**Harnett County**  
420 McKinney Pkwy

**SUBJECT: SFD2504-0072**  
**SINGLE FAMILY DWELLING**

Here are the results of all Inspections located at **7986 OVERHILLS RD:**

FOUNDATION PLAN

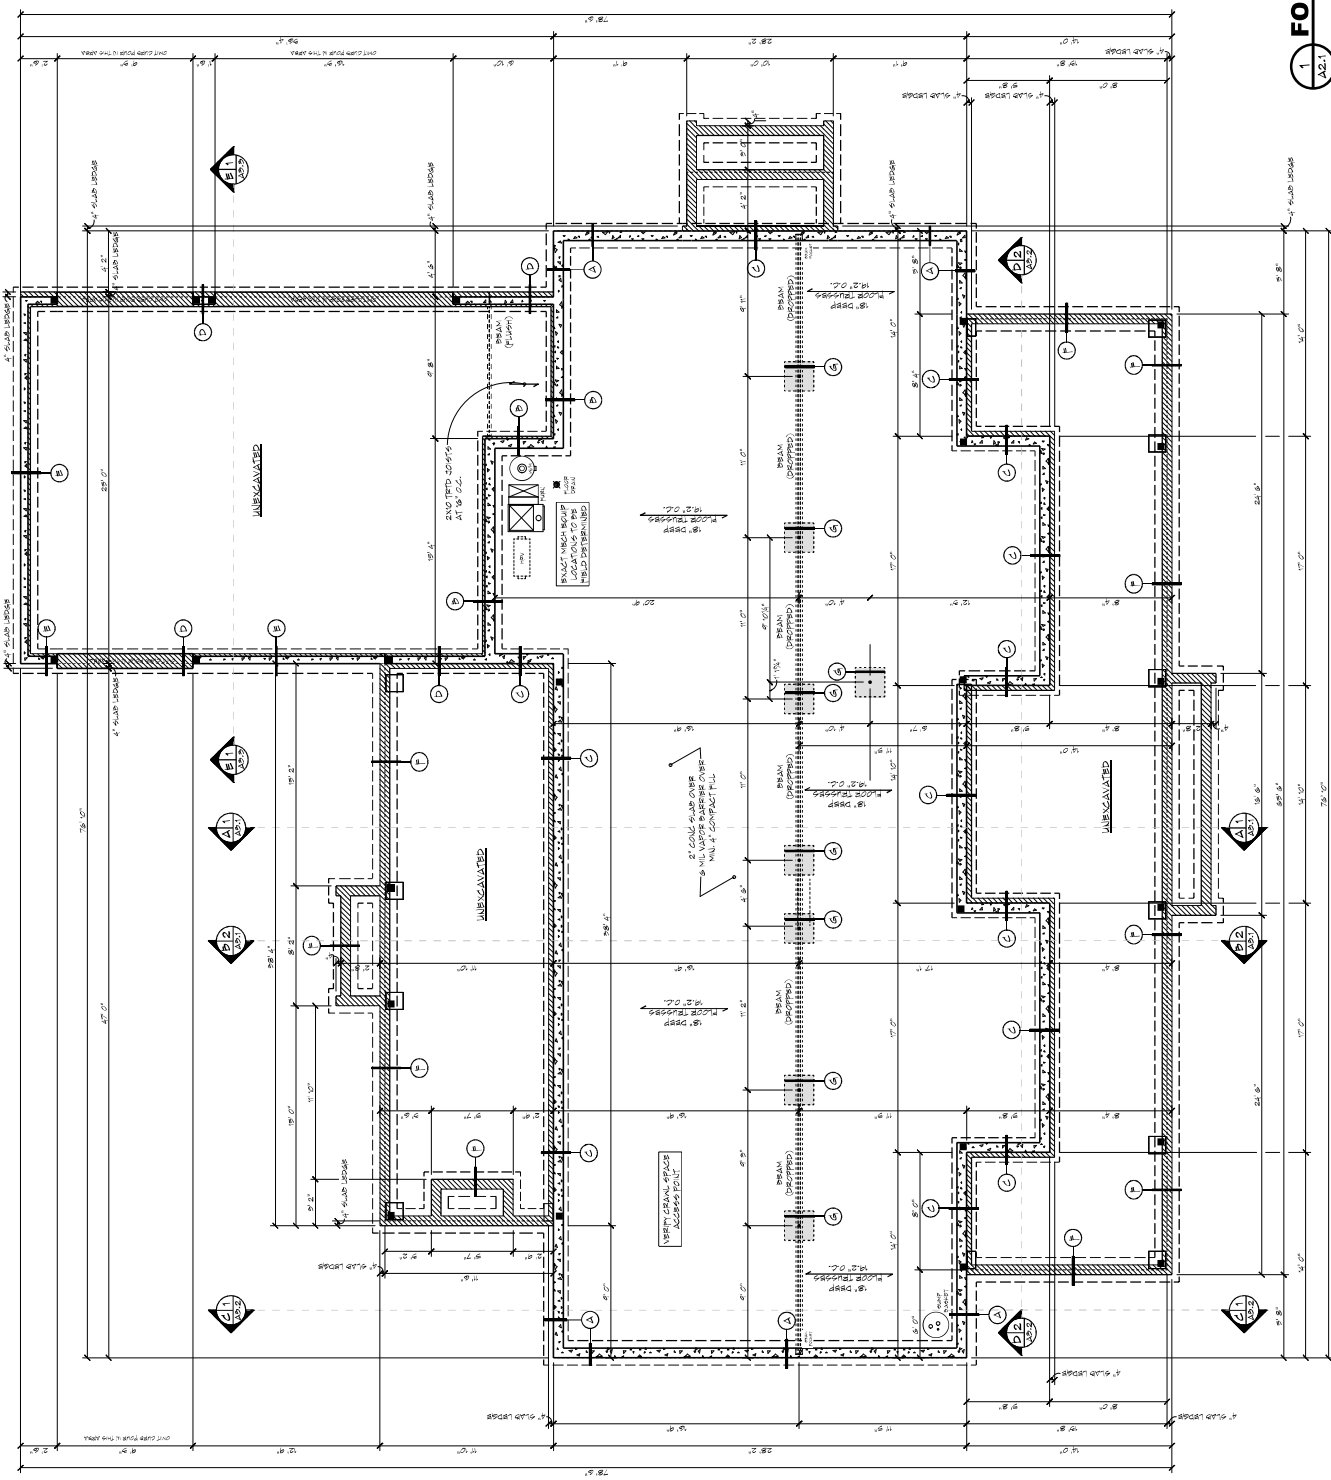
Need engineer letter for unstable soil in footings Remove all wood stakes from, footings for inspection

1. Uncover all footings for inspection
2. Missing damp proofing on foundation wall per code
3. Center of piers are not in the center 1/3 of the footings and need engineers third party letter for repair made on one pier footing

footings ready for inspection. Engineers letter in permit box

Inspection Type: FOOTING  
Scheduled Date/Time: 10/23/2025  
Completed Date/Time: 10/23/2025  
Inspector: James T Hall  
Result: APPROVED  
Remarks:  
Notes: For 1 pier in crawl that was moved

Inspection Type: FOUNDATION  
Scheduled Date/Time: 10/27/2025  
Completed Date/Time: 10/27/2025  
Inspector: Kory S Denny  
Result: APPROVED  
Remarks: eTRAKiT Inspection Request  
Notes: 10/24/2025 7:34 AM Branden Toth  
Pier rebuilt and ready for inspection, Water profing completed  
Contact Name: Branden Toth  
Site Address: 7986 OVERHILLS RD  
Phone: 9843045554  
e-Mail: branden@pbdnc.com
